SECTION 75 W APPLICATION - ACCESSIBILITY REVIEW

Commercial and Retail Development

100 Mount Street, North Sydney

Date: 19th August 2011

Approved: Ground Floor (Level 6) FFL: 53.85 (Lobby)

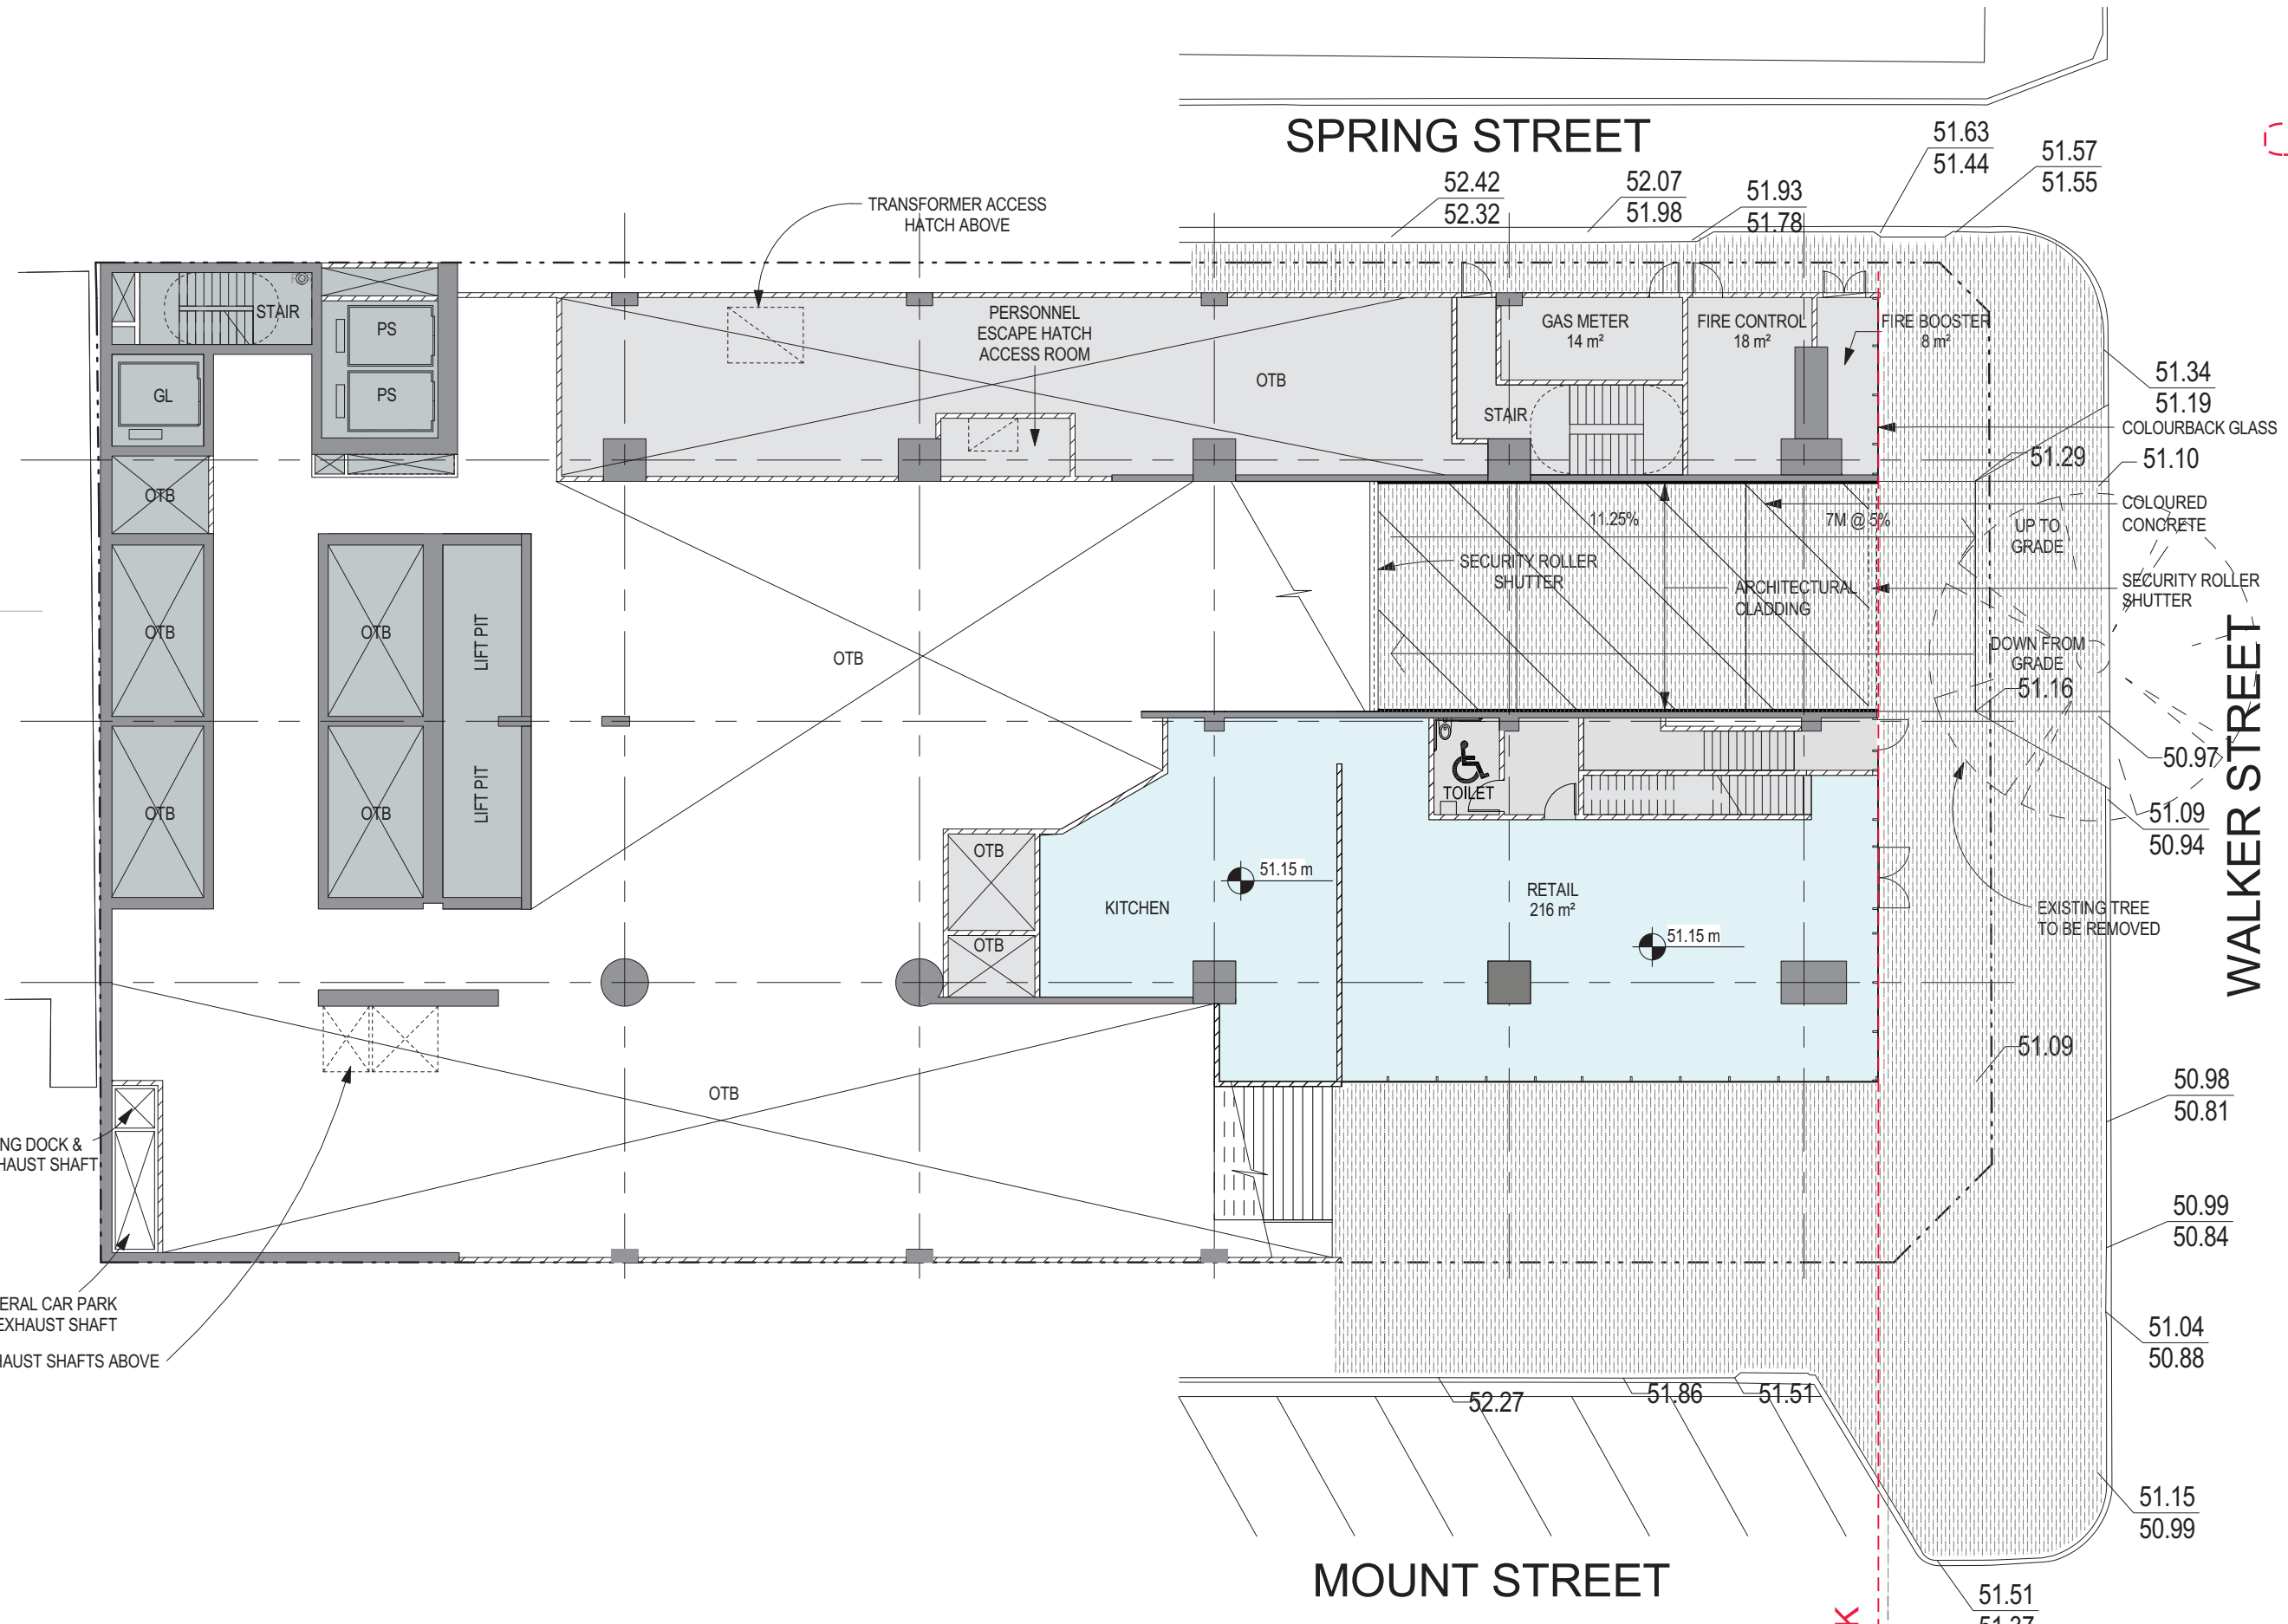
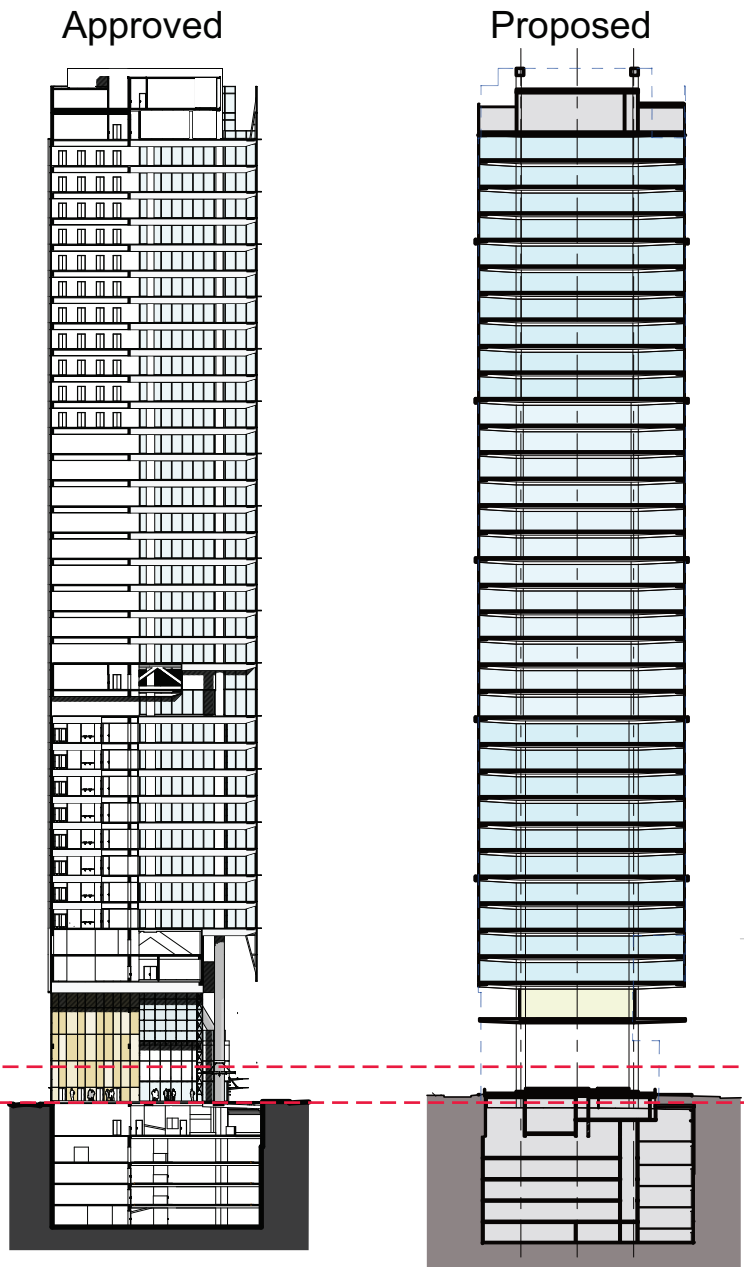
- The existing topography of the site may limit access by people with disabilities between the Walker Street retail entrance and Ground Level entrances.
- The proposed transition between the ramped external walkways on either side of the building (North and South) and the seating platforms requires confirmation.
- The crossfall of the external pathways is yet to be confirmed.
- The location of drainage pits to be confirmed.
- Limited documentation has been provided regarding proposed external finishes.

- The provision of stairs only limits access between Ground Floor and the Retail Level. However, it is understood at this stage that the spaces will operate as separate venues with access for service staff only.
- There is limited access to the raised seating platforms located on Ground Floor.
- The proposed clearance widths to the secured entry at Ground Floor requires confirmation.

- 4.2.1 Further discussion is required as the designs progress in order to specify the relationship between the Ground Floor and the Retail Level to ensure access for people with disabilities is provided as required.

- 4.3.1 Further discussion is required as the designs progress in order to specify the function of the proposed stair between Ground Floor and the Retail Level, including suitability for access by service staff only.
- 4.3.2 Develop ramped access to the raised seating platforms. This may be achieved by the incorporation of a mid-landing to the proposed external ramps.
- 4.3.3 Confirm a minimum clearance of 1000mm to not less than one secured entry at the Ground Floor.
